CITY OF ALBUQUERQUE

April 14, 2022

Re: CARMEL APARTMENTS A
7310 Carmel Ave. NE
Traffic Circulation Layout
Architect's Stamp 03-03-2022 (C19-069A)

AS-2.0

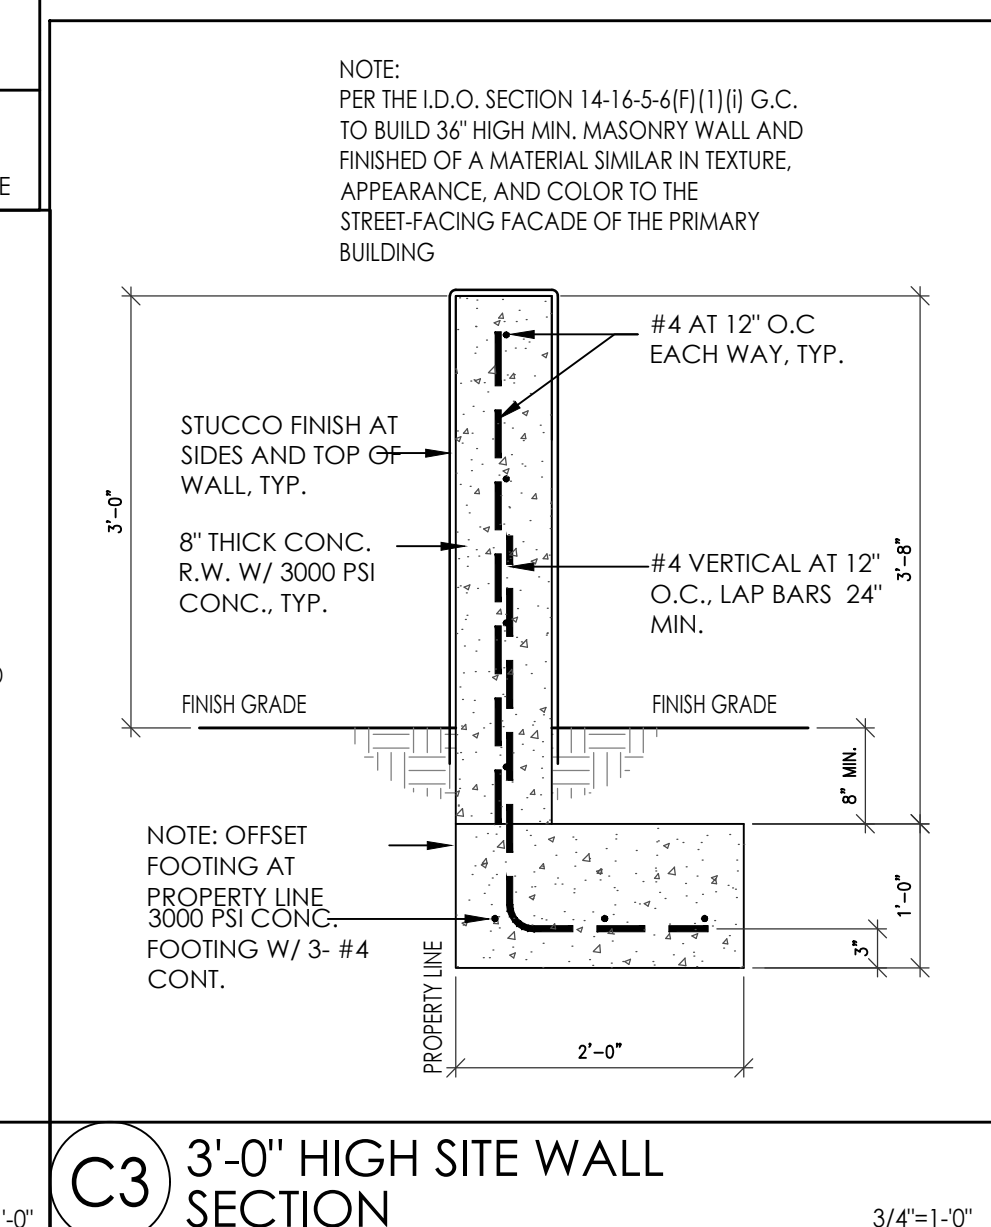
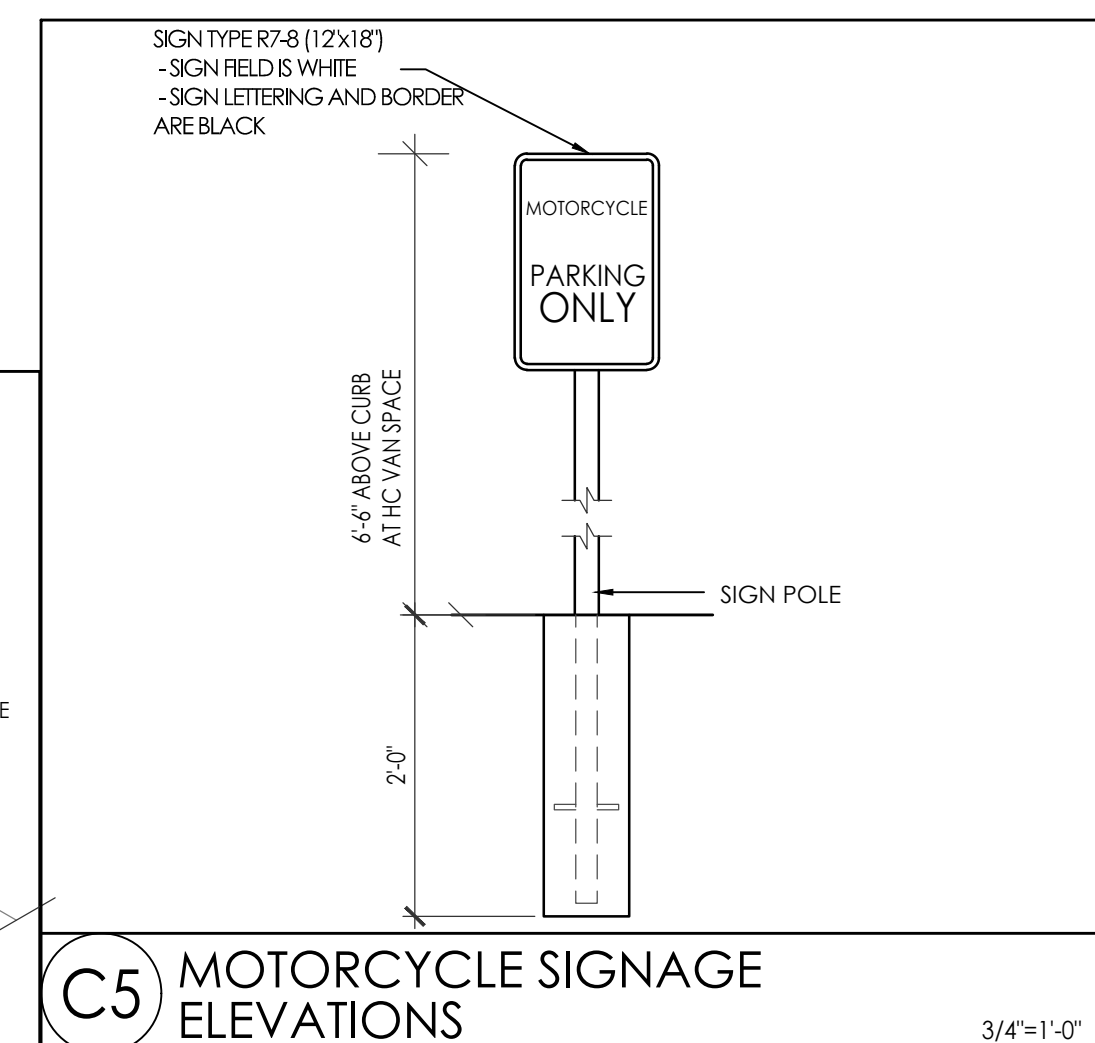
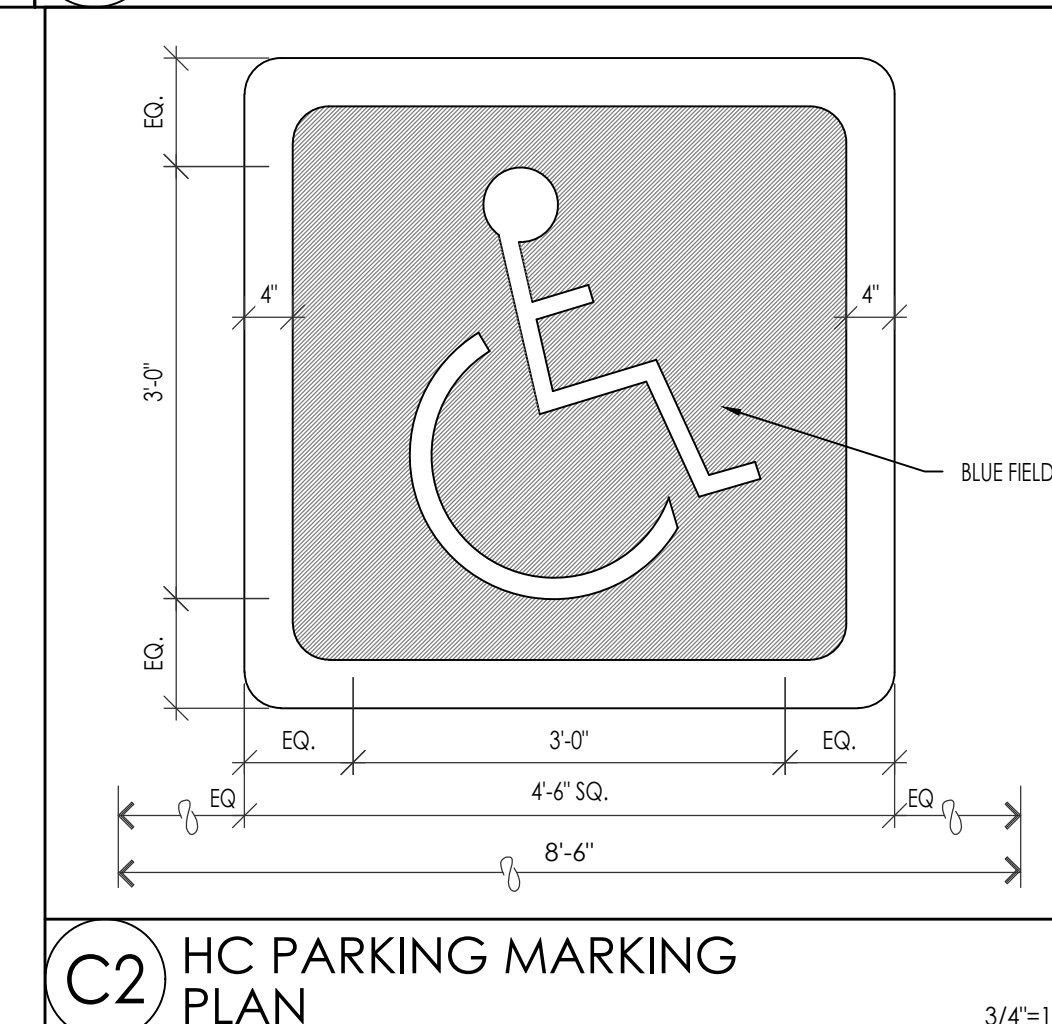
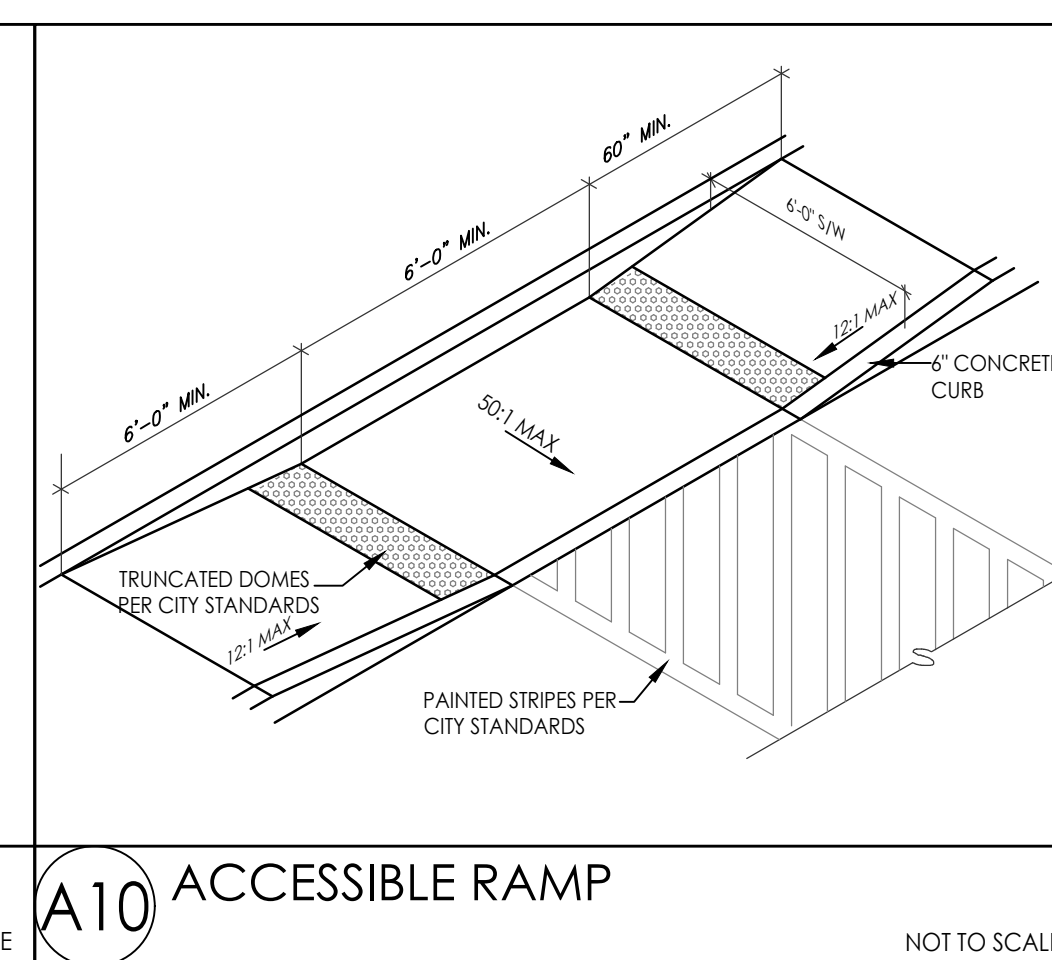
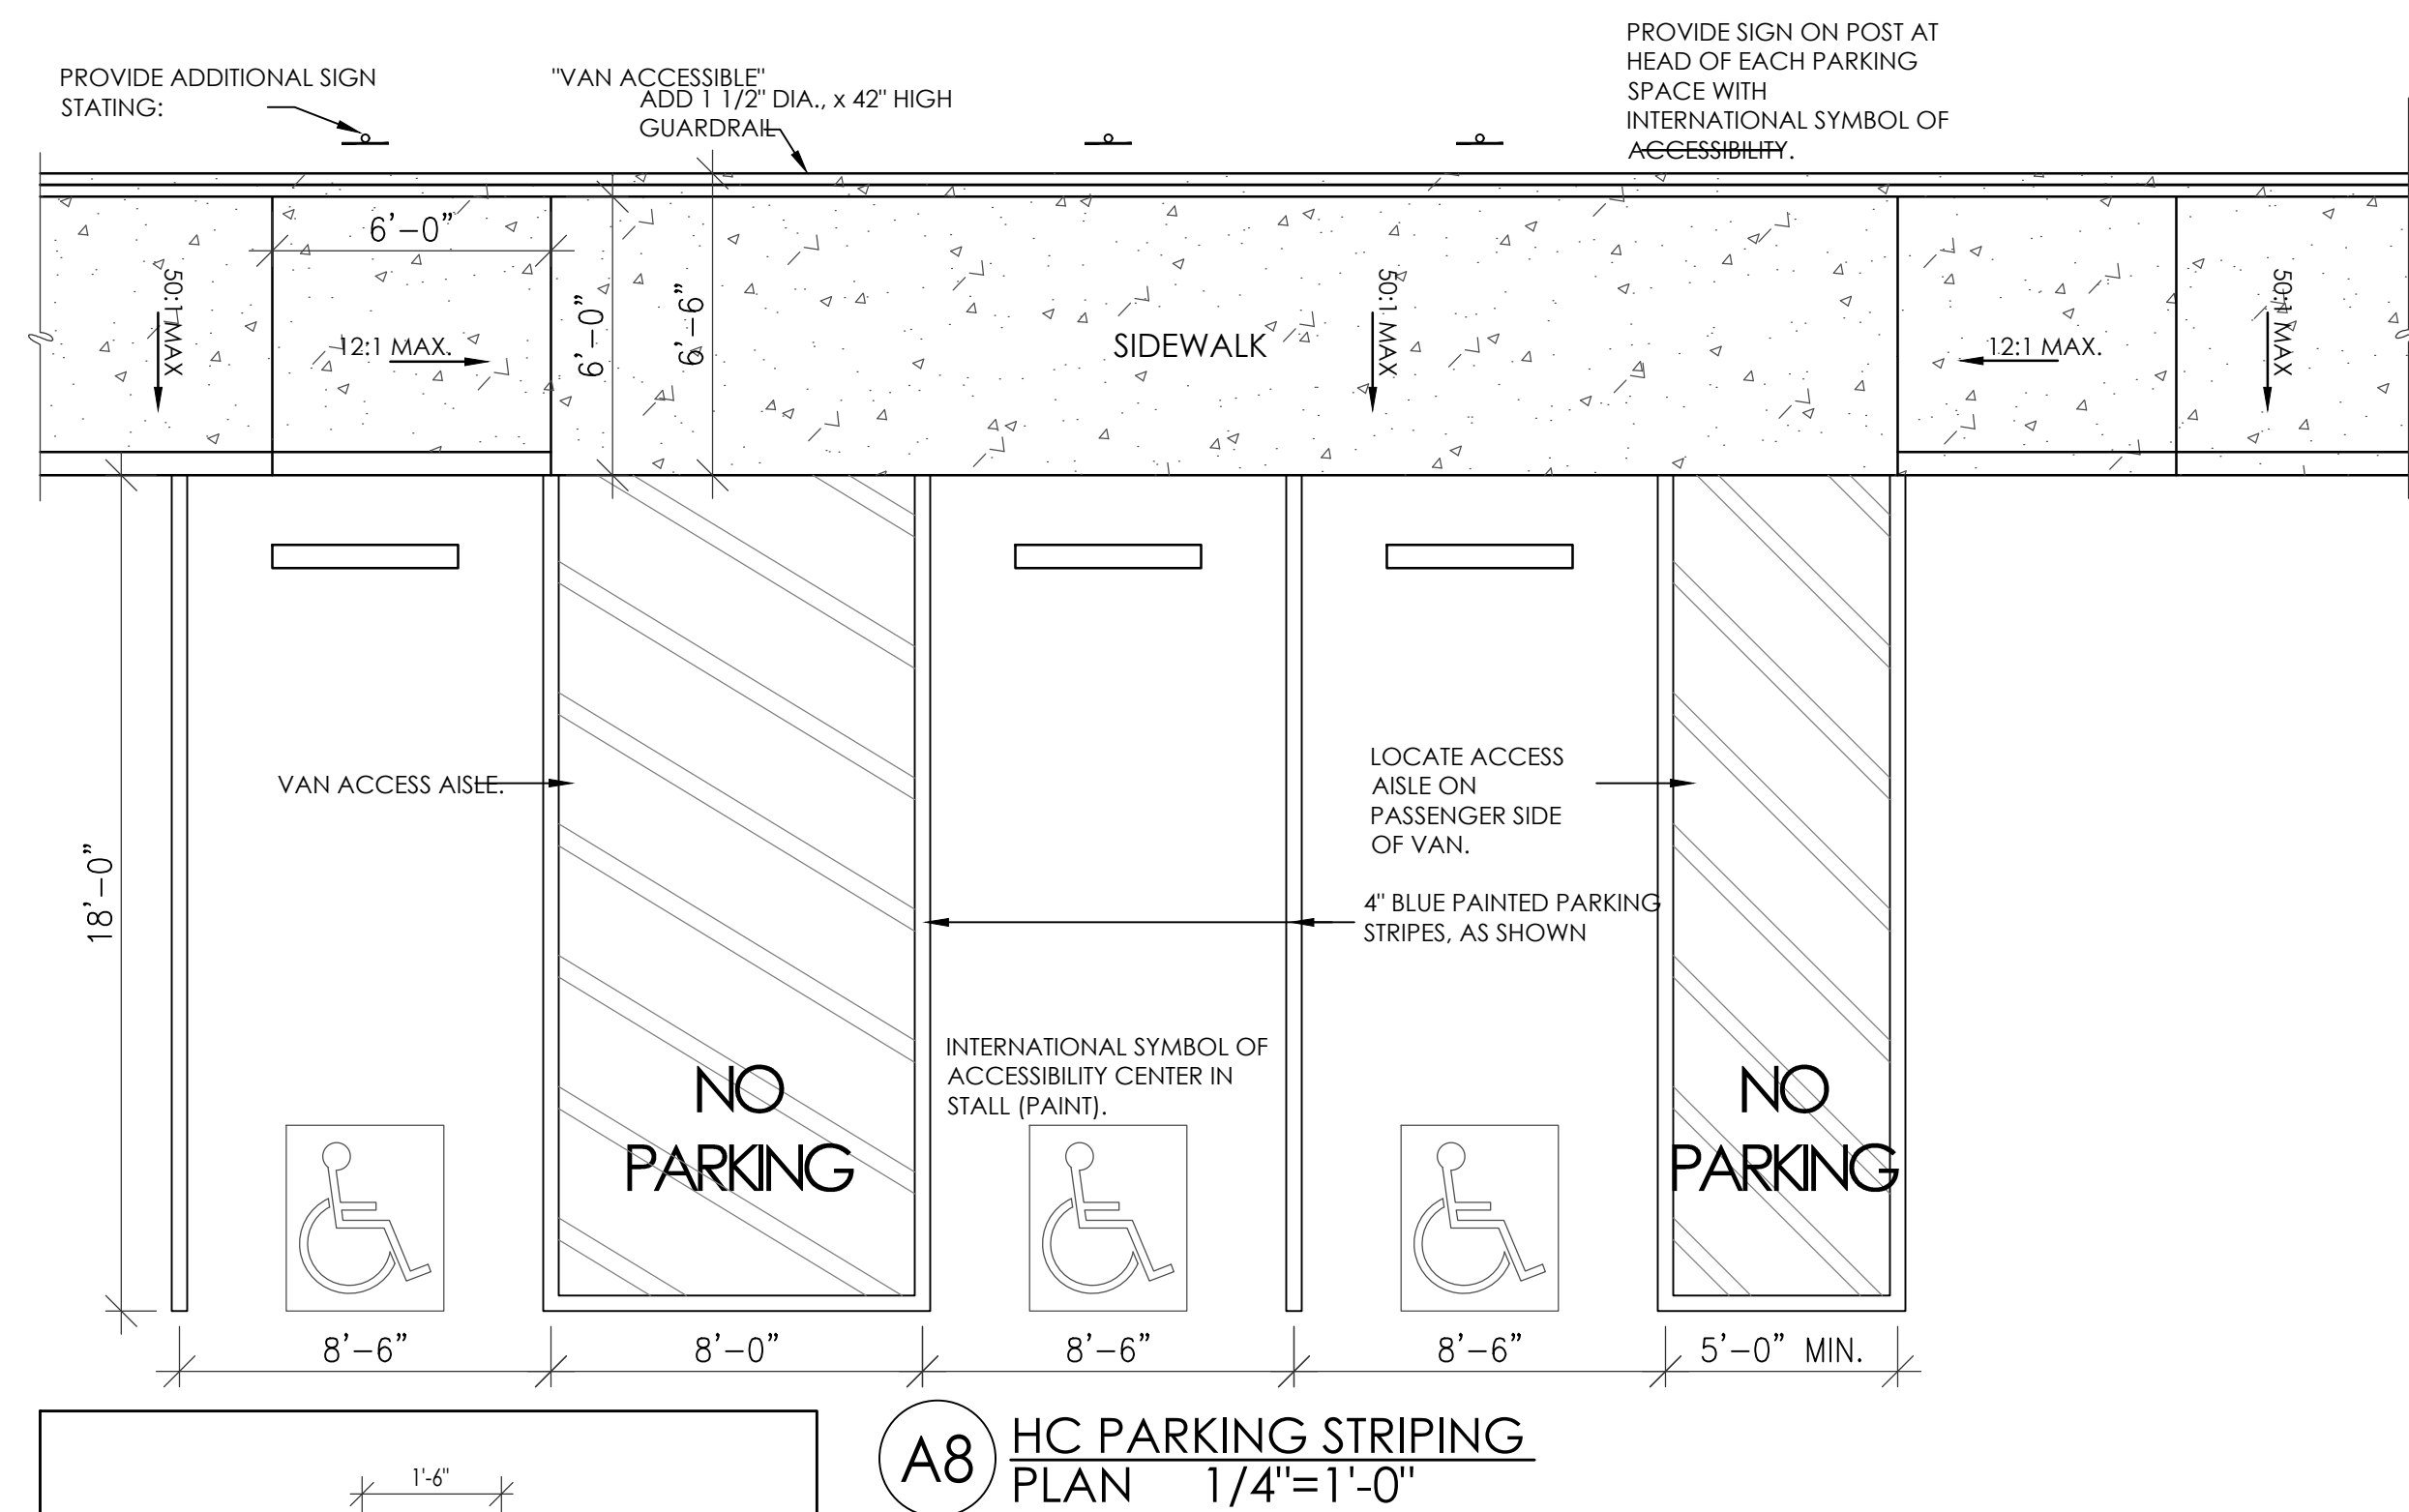
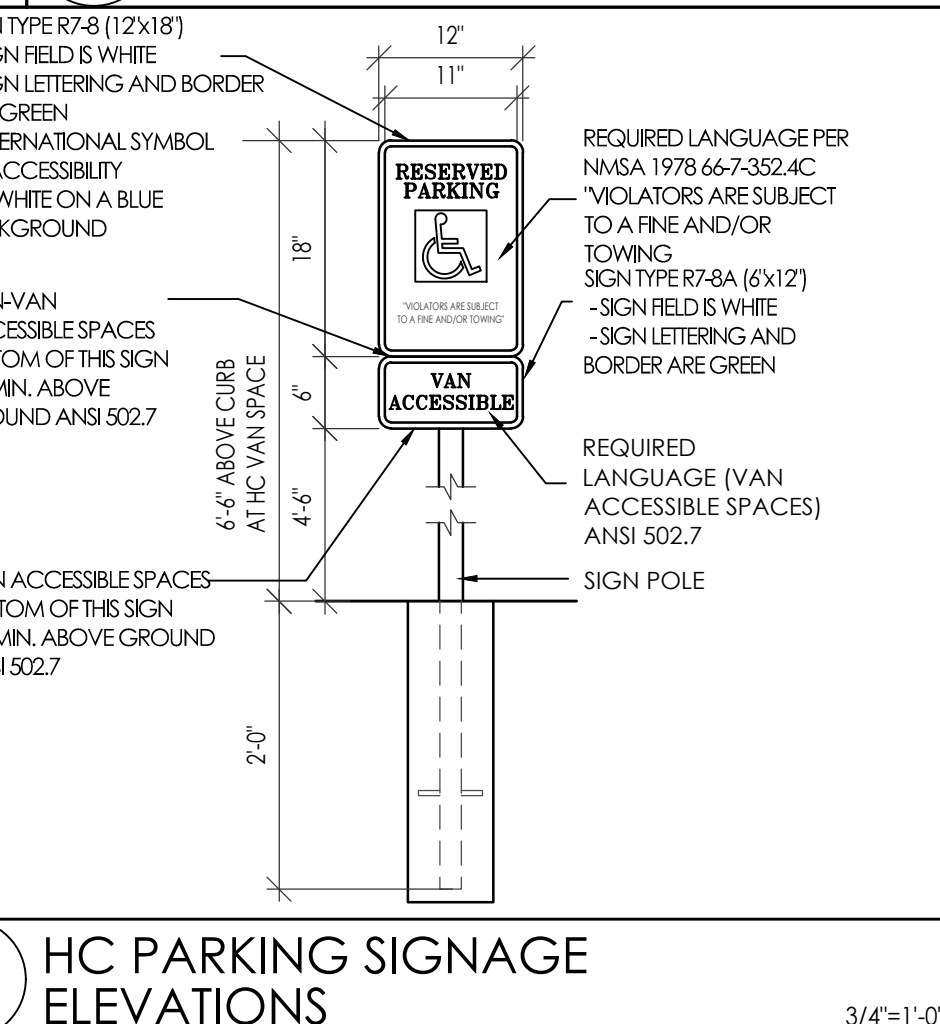
7. **Detail A4:** Paint Bollards yellow.
 8. **Detail A8:** Note 50:1 max on top of sidewalk and 12:1 max for taper. Stall widths are 8'-6" not 8'-0"-6" please adjust text.

9. **Detail A10:** 50:1 and 12:1 should have the word max. after each text.
 10. **ADA Parking Access Aisle dimensions (on site plan):** You specify 8'-6" on layout but on detail you call out 8'-0". Please address this concern.
